City of Albuquerque

RE: ENGINEER'S CERTIFICATION FOR MANZANO BAPTIST CHURCH
(L-22/D47) RECEIVED NOVEMBER 16, 1990

PROJECT TITLE: MANZANO BAPTIST CHURCH ZONE ATLAS/DRNG. FILE #: L-22/D47

#### GRADING & DRAINAGE PLAN

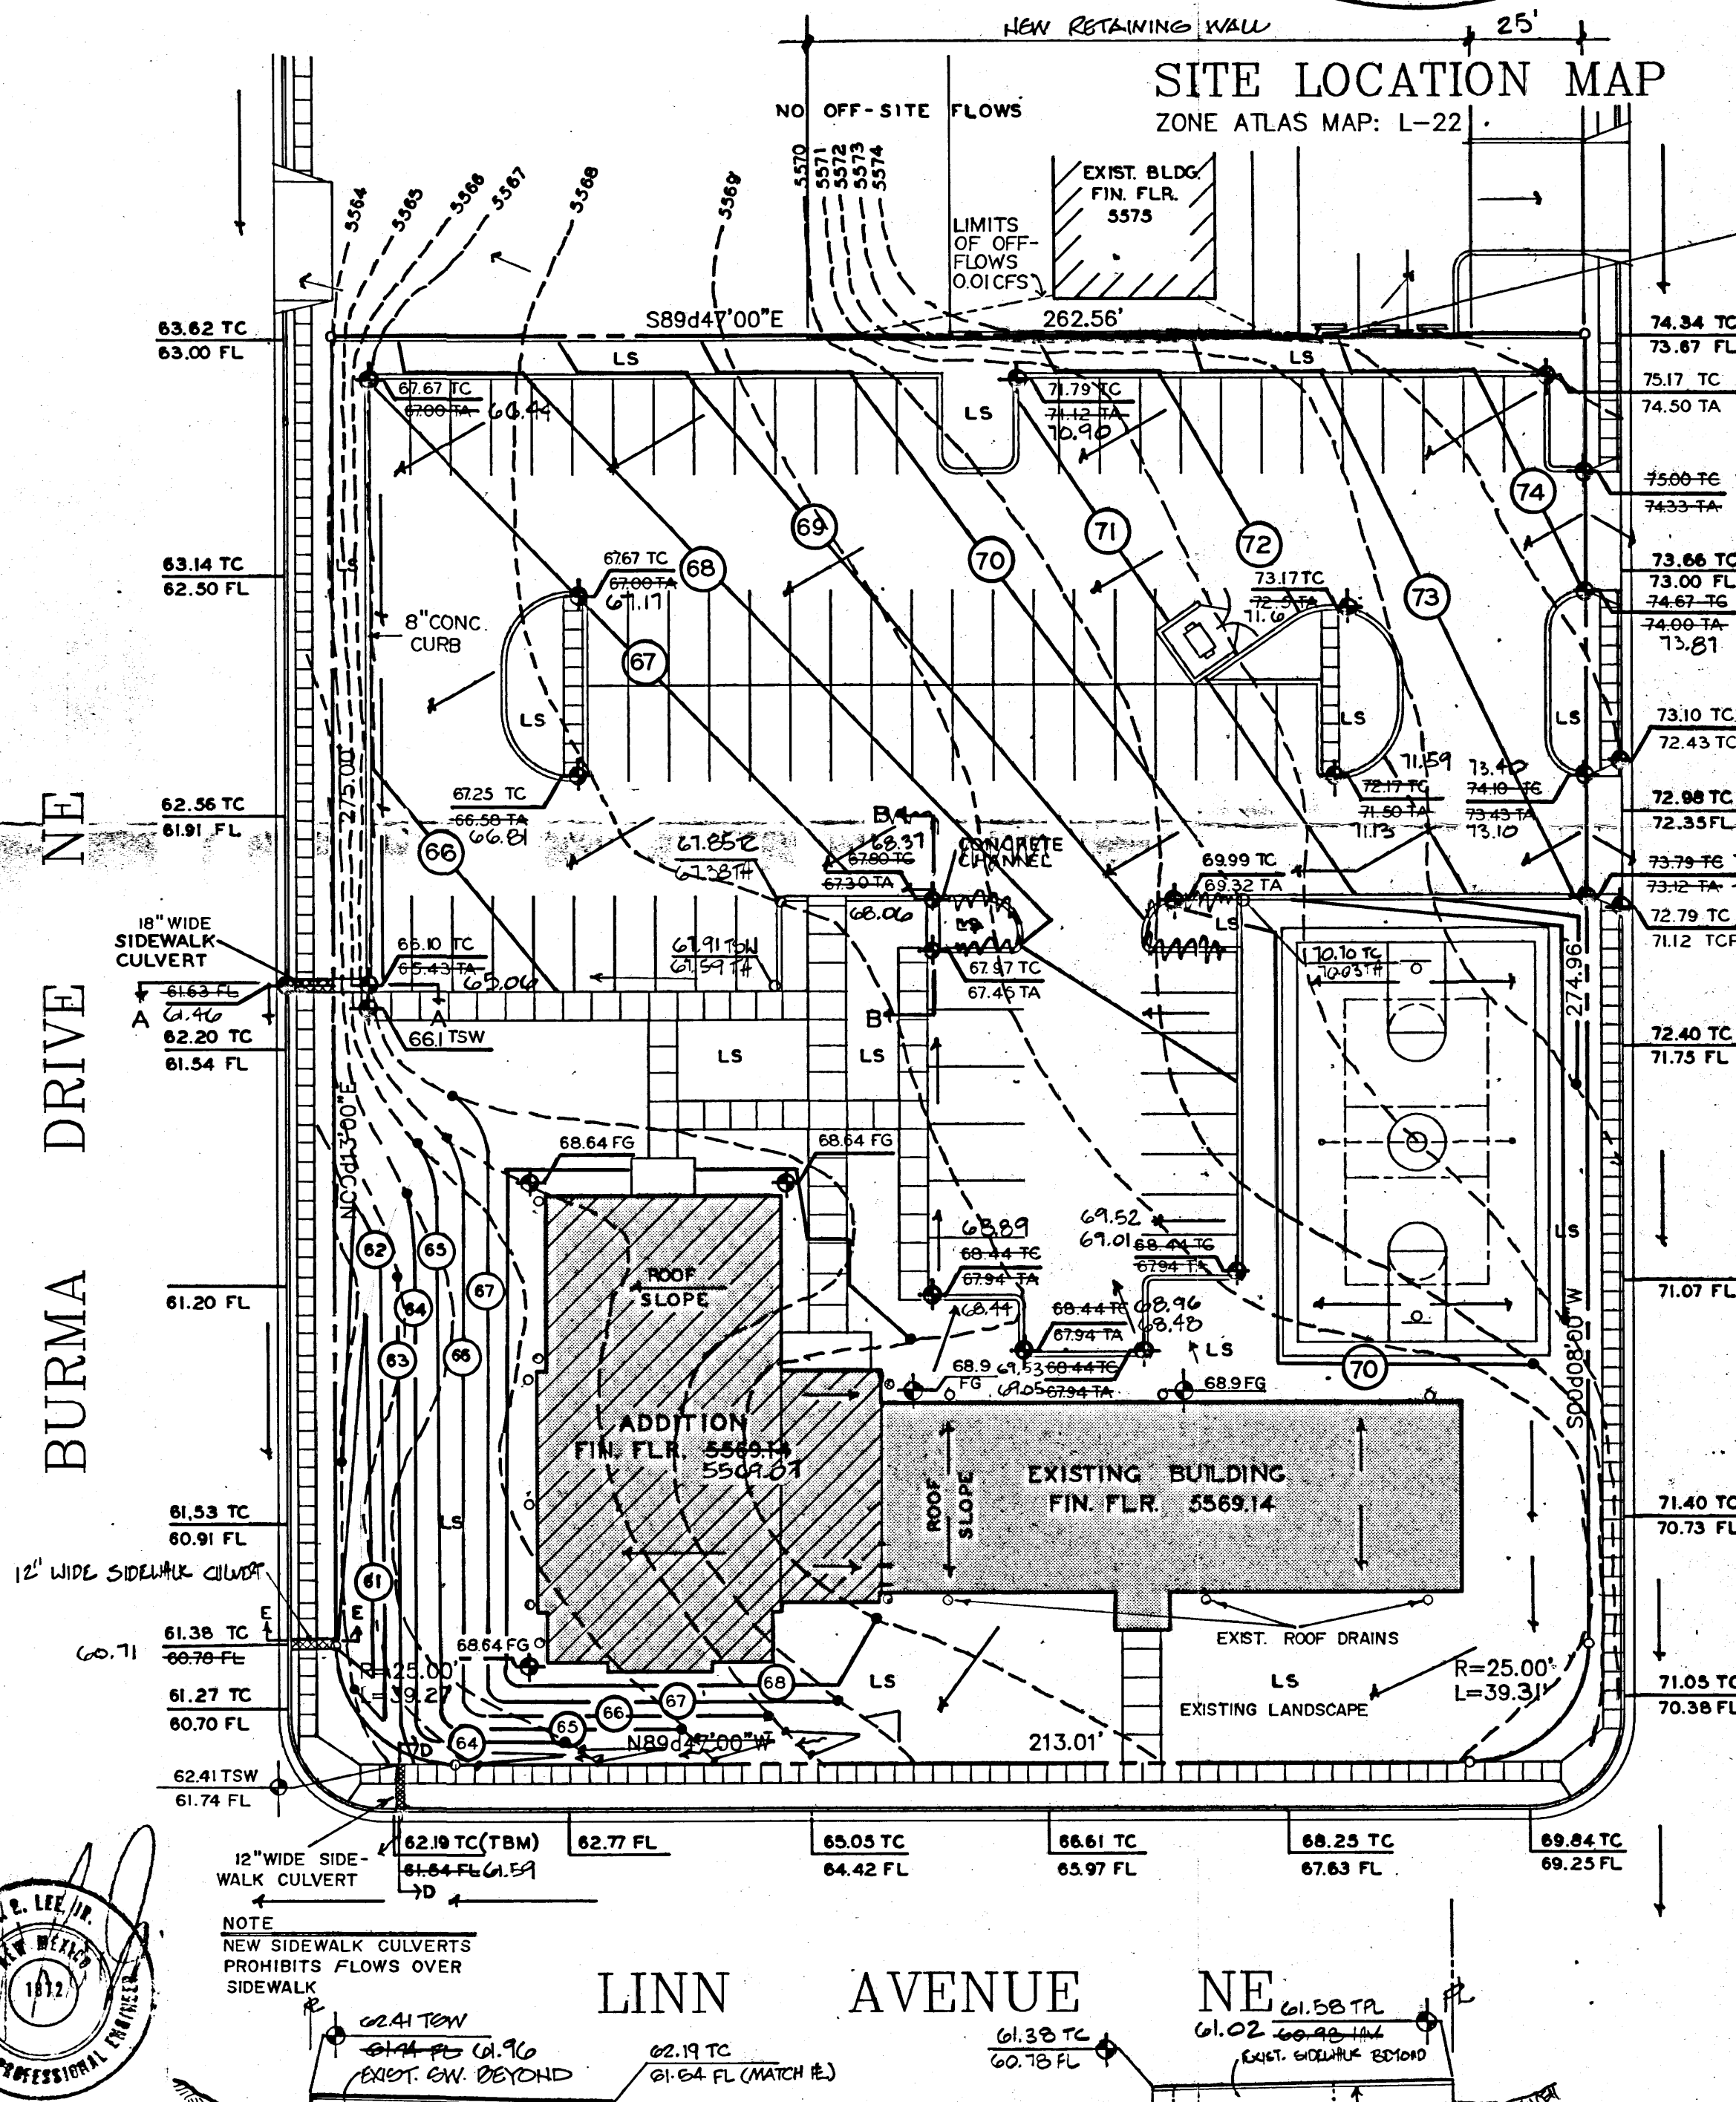
Please be advised that the Certificate of Occupancy will not be released until we receive concurrence from construction for the S.O. #19 work. The DPM checklist indicates that with your certification submittal, you must provide copies of construction approval from the appropriate government agencies for construction within their right-of-way and or easements.

Complaint: RUNOFF FROM THE CHURCH IS CAUSING PROBLEMS IN
LINN ST WITH RESPECT TO THE ROADWAY AND IS
CAUSING ICING IN THE ROADWAY WHEN IT FREEZES

Investigation-Comments: GRADING STILL NOT TO PLAN AS
PER INSPECTION ON 9-18-89 SWALE NOT IN PLACE
NO STREET DAMAGE VISIBLE ON 1-18-90 + 1-22-90
AFTER SNOW STOP
